From:
Sent: 09 November 2024 17:27
To: DC Admin; Lucy Taylor;
Subject: Application Number 2024/62/92819/W

Application Number 2024/62/92819/W

DRAWING TITLE  
EXISTING AND PROPOSED SITE PLAN

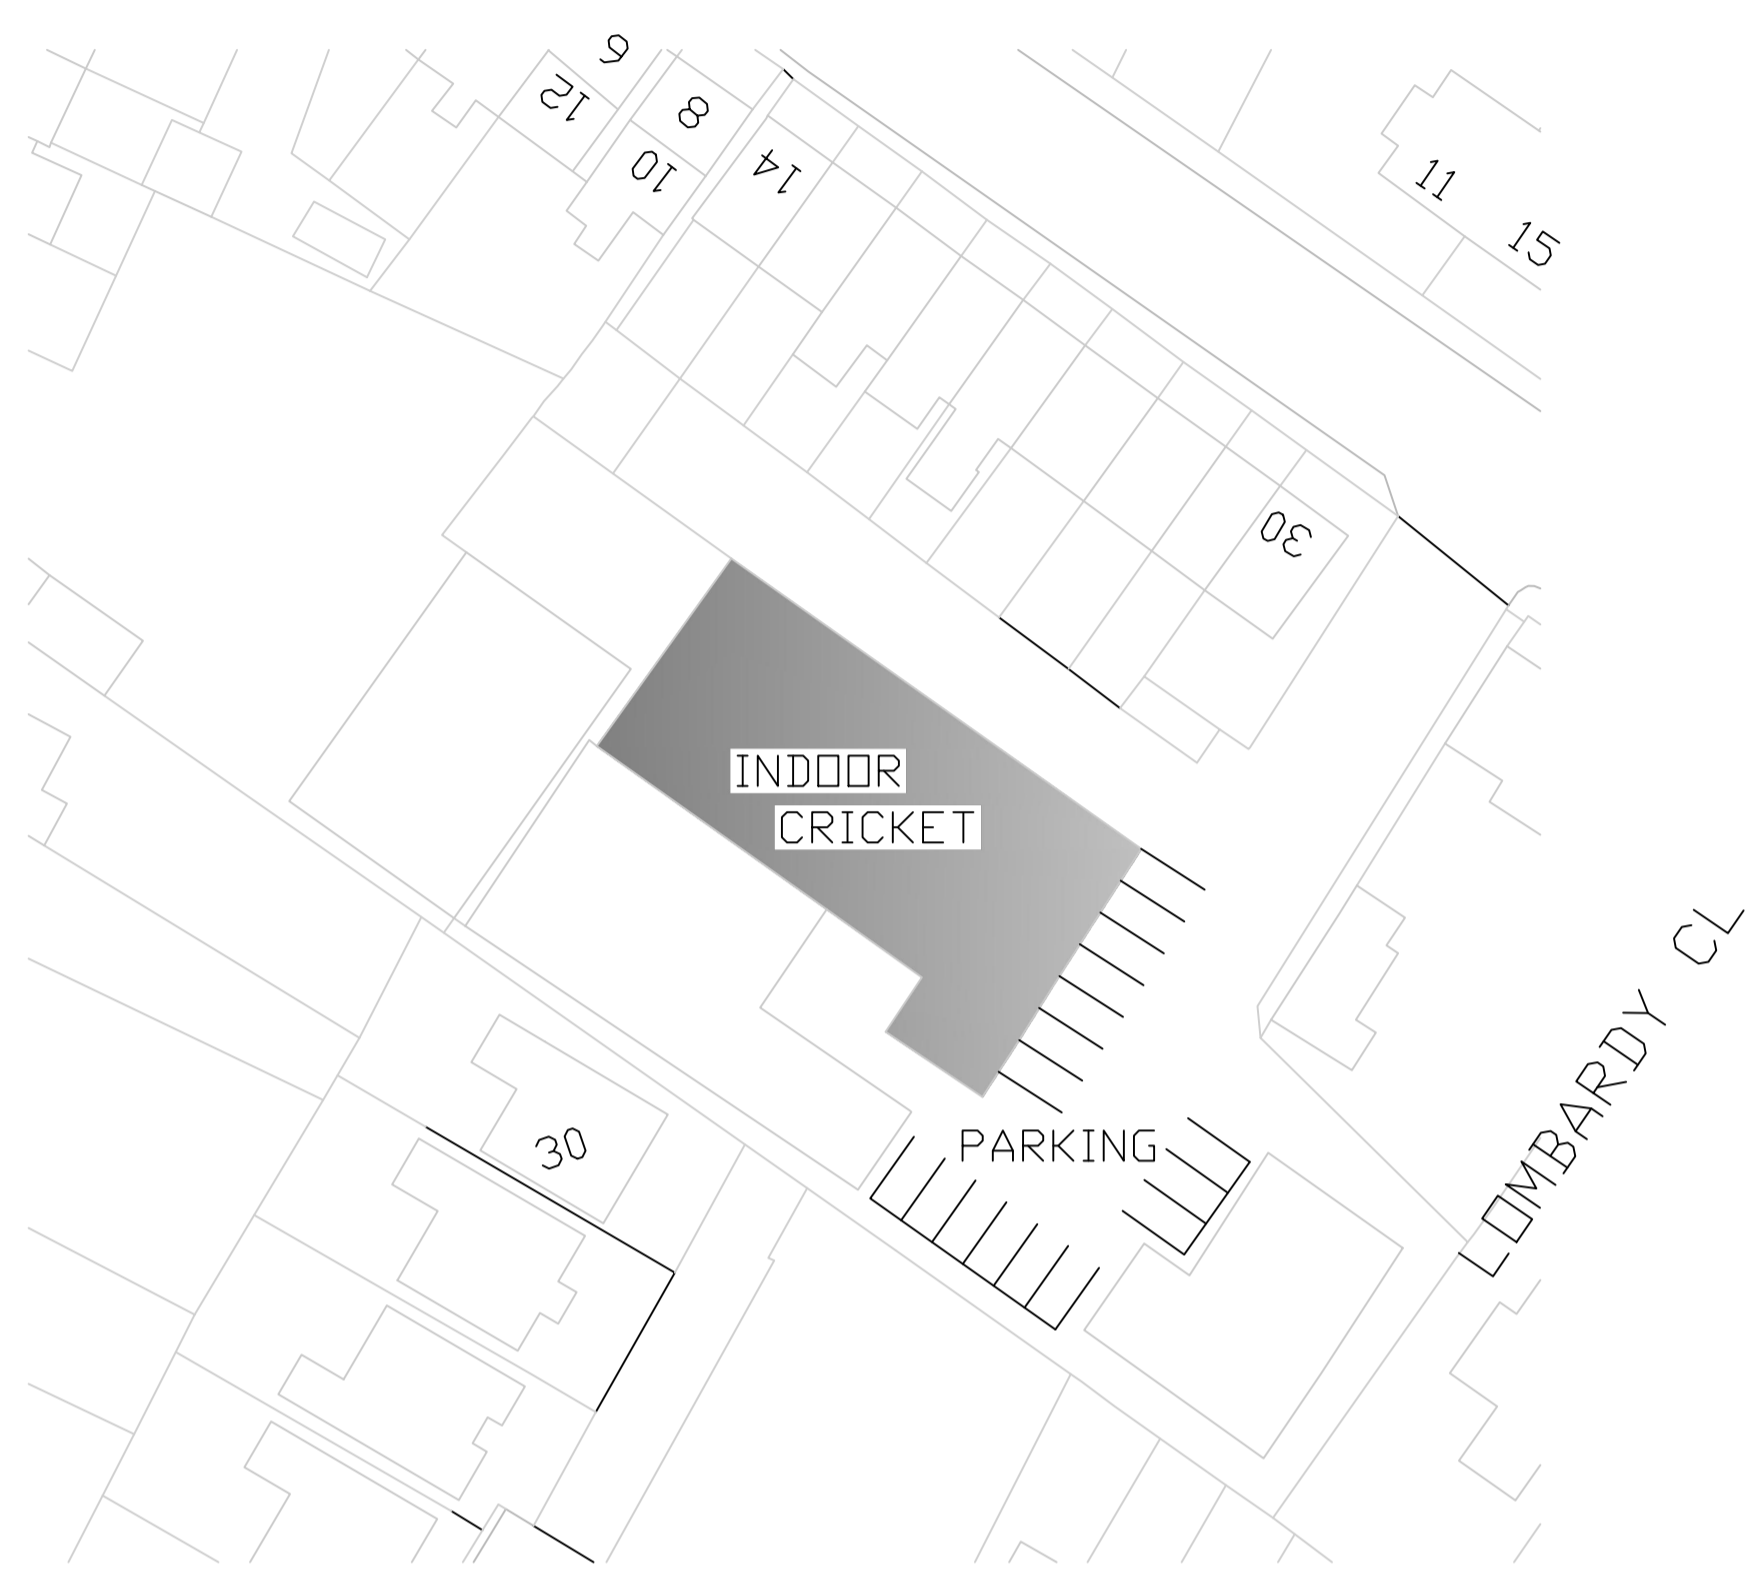
There is no room for 16 car parking spaces, several of which are marked on the plans on property not owned by the landlord, also for a commercial venture this could potentially mean up to 100 cars a day up and down an unpaved, unadopted road, the noise from which would create havoc and leave residents with no parking outside their own homes and cause access issues to the rear of my property which I use on a daily basis. The noise from people shouting and the noise of balls striking walls, windows and the roof would be heard inside my property that backs directly onto the proposed plan, the light pollution would shine directly into my dining room, back bedroom and bathroom, this will also have an impact on my wife's place of work as she works from a home office, noise pollution would severely impact her ability to carry out her tasks

I also appears that the plans seem to cover part of my land on the access path at the rear of my property. The previous tenant put a loading bay door onto a building that on the original planning application was a fire door. I have made several complaints about the articulated trucks that would reverse down said path to unload into the former furniture factory, this path, as it is a path and not a road, it is unpaved and unadopted will not support traffic of any kind and could potentially cause a collapse of sewers running underneath said path I steadfastly oppose this application and would rather see the building torn down and replaced with houses. I am happy to have my name on the comments and do not care about anonymity, I will not be intimidated, this is my home.
